On 23 March Anglian Water wrote to Augean seeking the provision of information to enable consideration of the stand off distances for the two mains pipelines. On 29 March at the Issue Specific Hearing Anglian Water set out these concerns. These concerns are summarised below.

Figure ESA5.1 Scale: 1:2,500@A2

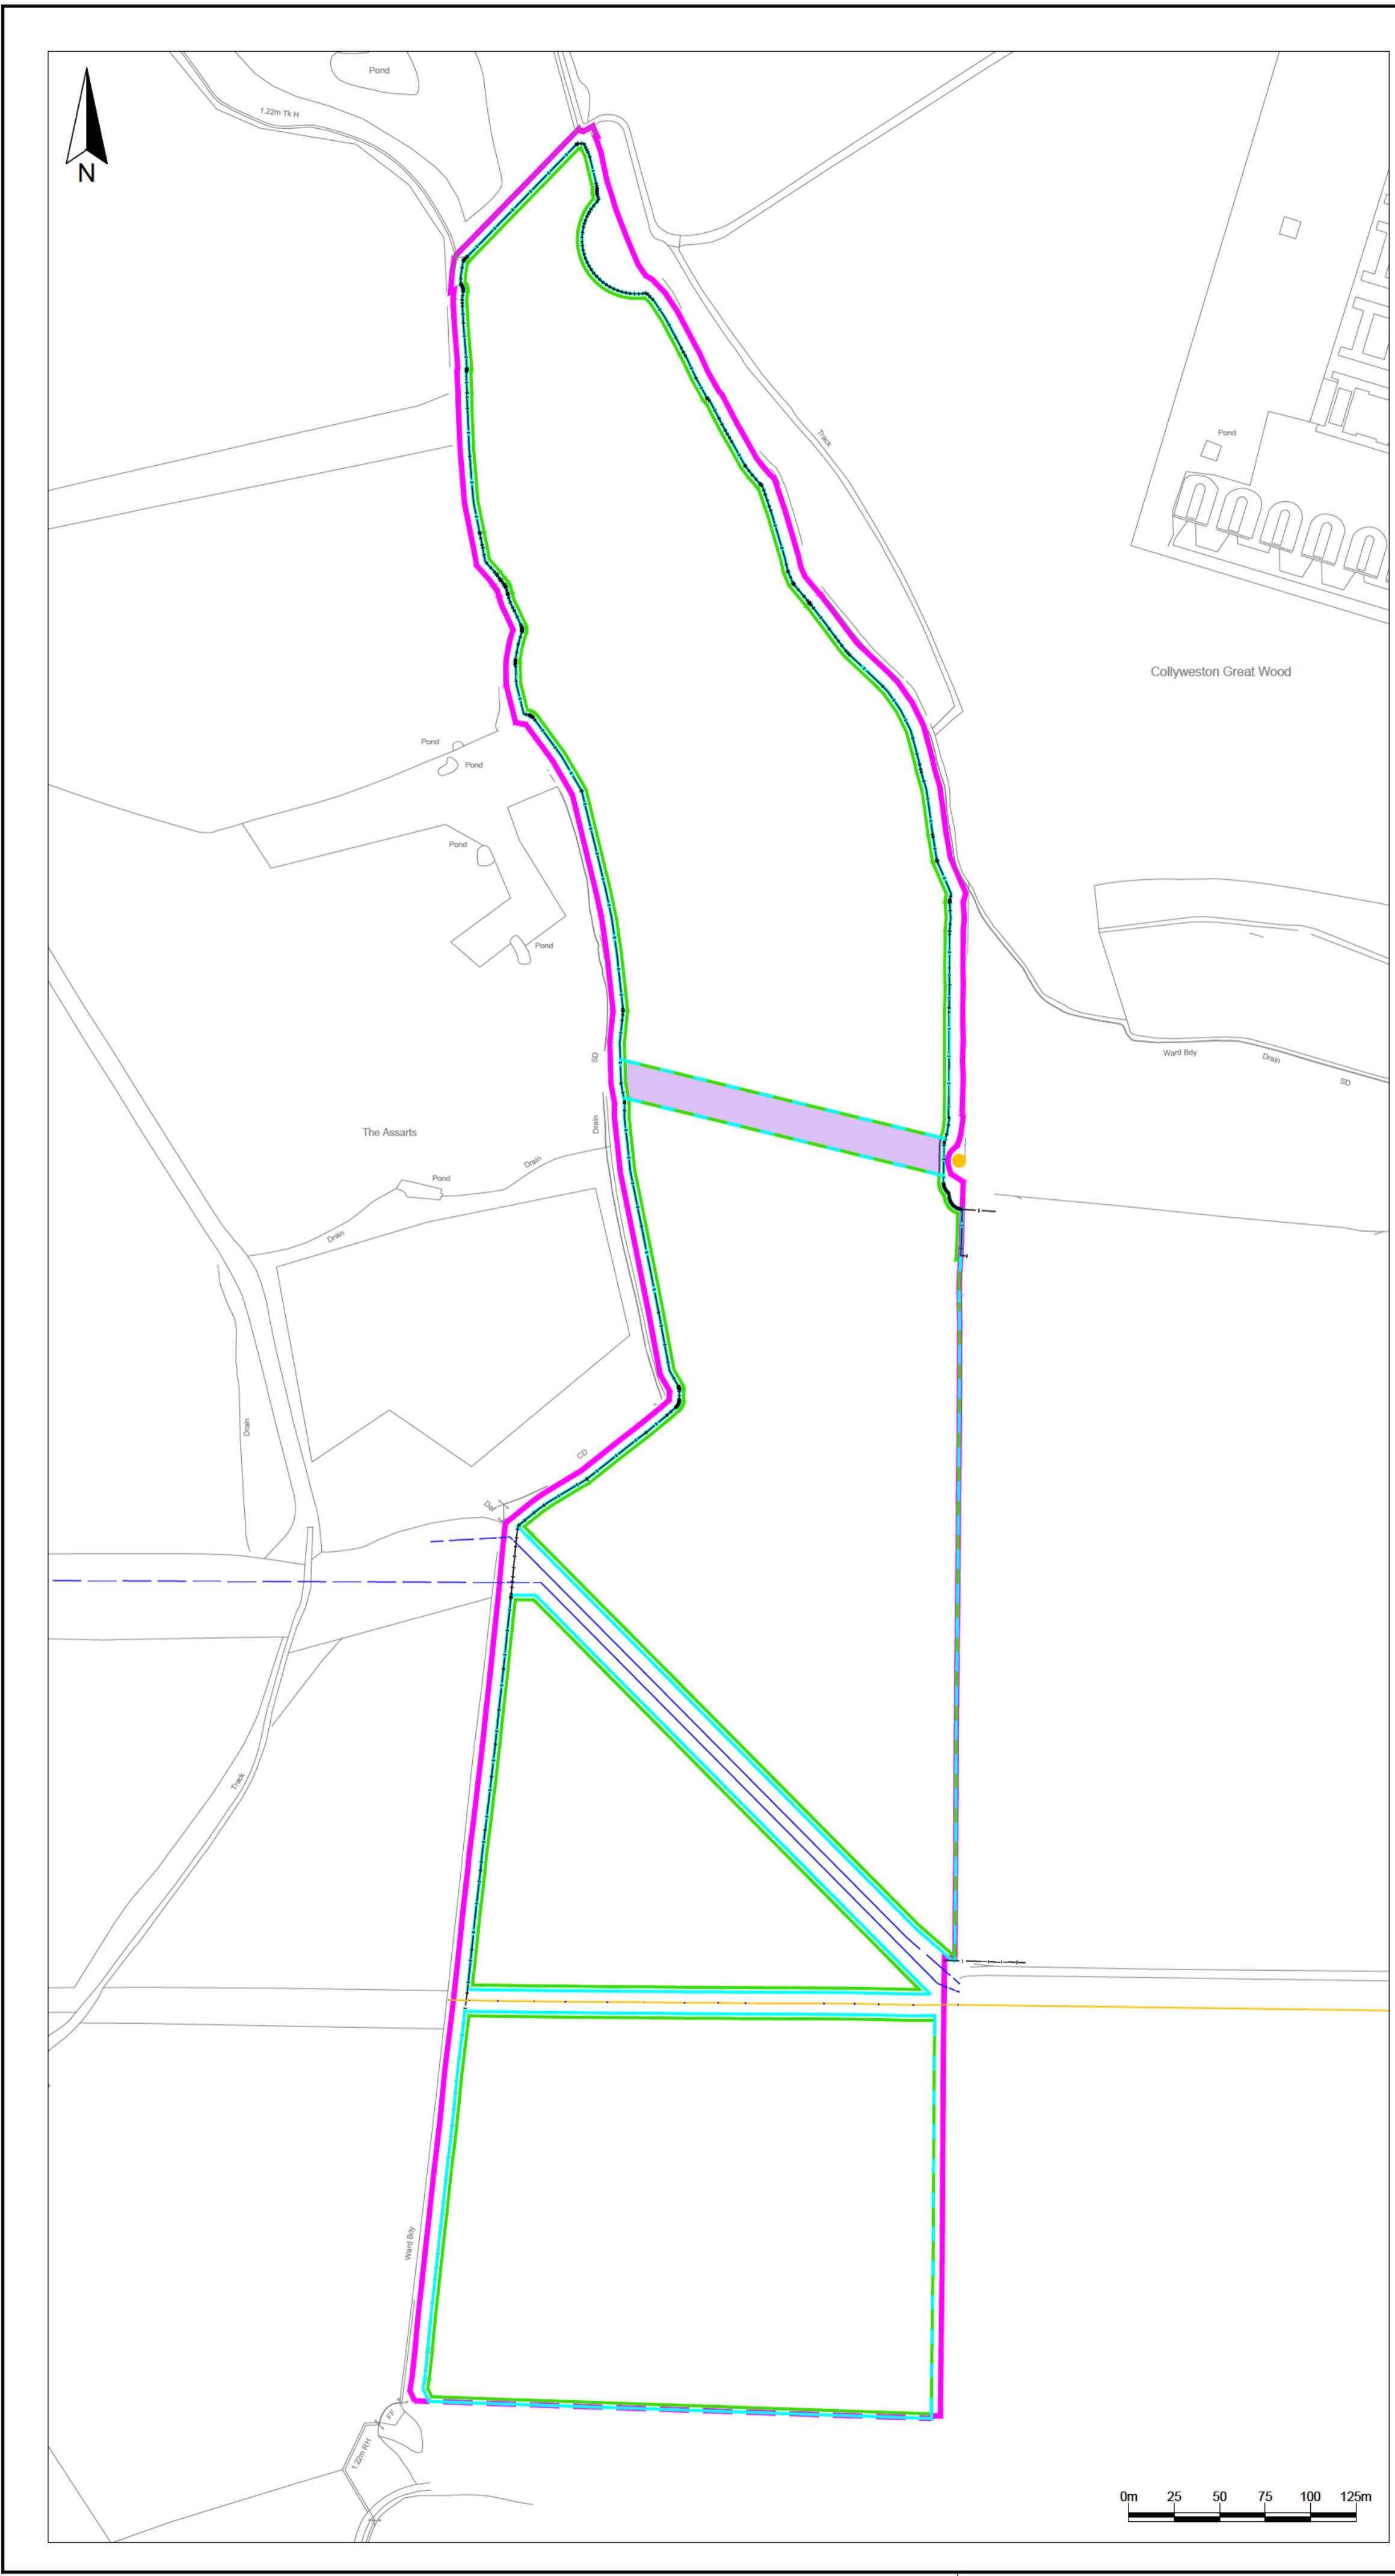
In the absence of the consideration of the risks to the water pipelines, Anglian Water advises that our first preference is for the water pipelines to be relocated to land outside of the construction and operational area for the ENRMF. The limited information provided by Augean suggests that standoff distances either side of the two pipelines would need to be in excess of 20 metres to enable safe access. The relocated Western Power electricity transmission cable would need to be outside the 20m plus standoff and therefore next to the landfill cell area. The standoff distance is in part to enable safe work given there are two pipelines, the area is not flat farmland but between two engineered cells and work by Anglian Water or Western Power would require both a plant and machinery, a running area for vehicles and lay down areas for materials and excavations.
